**Application:** DC/26/00298  
**Location:** EcoPower Suffolk Solar Project  
**Proposal:** Consultation on Application received by the Planning Inspectorate - Scoping Opinion for the EcoPower Suffolk Solar project

**Ecopower Suffolk Solar – BMSDC: EIA Scoping Report | Reference: DC/26/00298**

**Environmental Impact Assessment Scoping Report Reference: 302827-00/EIASR Issue P01 (23rd January 2026)**

Role
Scoping Report

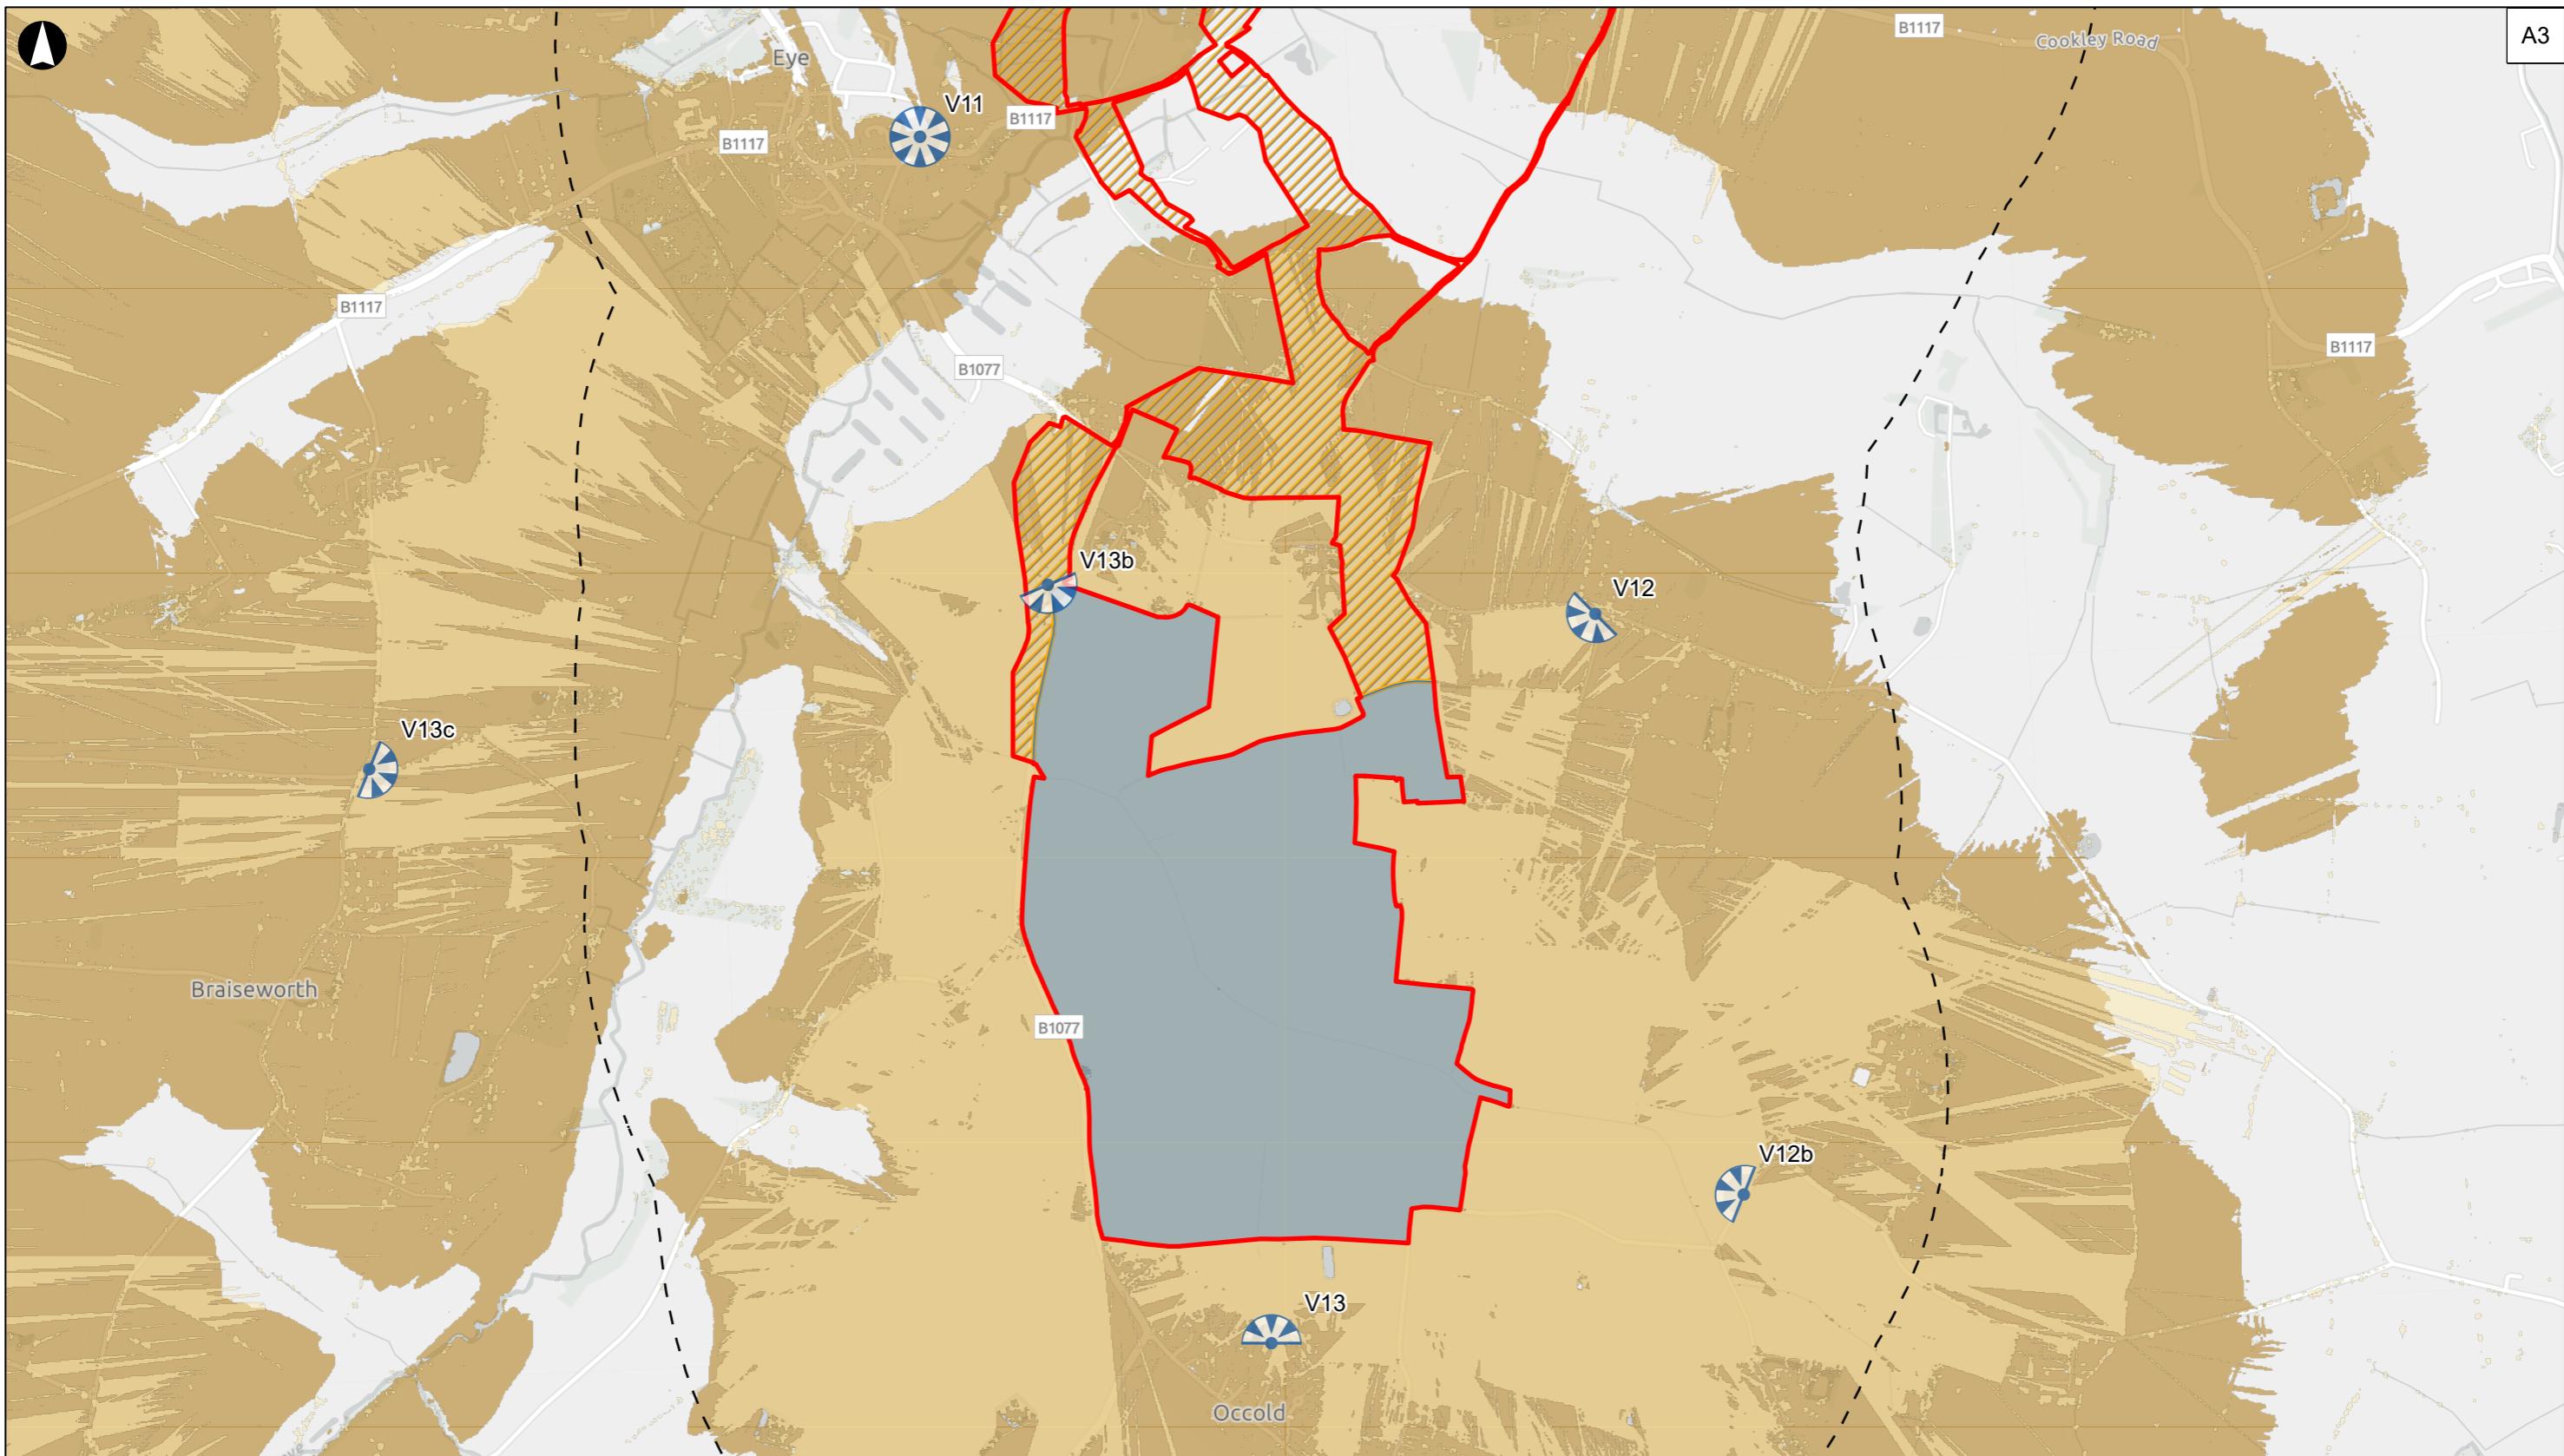
and we support the suggested criteria including consideration of physical and historic connectivity and relationships with other sites and the wider landscape as well as the Proposed Development's Zone of Theoretical Visibility which is shown in Figure 7.8. We note further that it is anticipated that Scheduled Monuments and Grade I and Grade II\* listed buildings located within the Study Area and within the ZTV are considered likely to be the most sensitive to changes within their setting based on the EIA methodology (though what value/sensitivity is to be assigned to these assets has not yet been set out).

- 1.11. We note the proposed viewpoint locations and directions shown on Figure 7.8 but consider that there should be additional viewpoints and visualisations to specifically inform the assessment of impact on the setting and significance of heritage assets.

- 1.12. Views looking towards and out from Mellis Conservation Area would be a key priority due to the proximity to Area 3 Gislingham and Area 5 Thrandeston and Mellis, including views from and towards the listed buildings located at the western end of the Conservation Area:

- Grade II Marsh Farmhouse (List entry number 1032768) – located to the north-west of Area 5 Thrandeston and Mellis
- 1.15. Further viewpoints and visualisations should be provided looking out from and towards the Thrandeston Conservation Area which is located to the east of Area 5 Thrandeston and Mellis. The following listed buildings are located at the western edge of the Conservation Area for which viewpoints and visualisations should be provided:
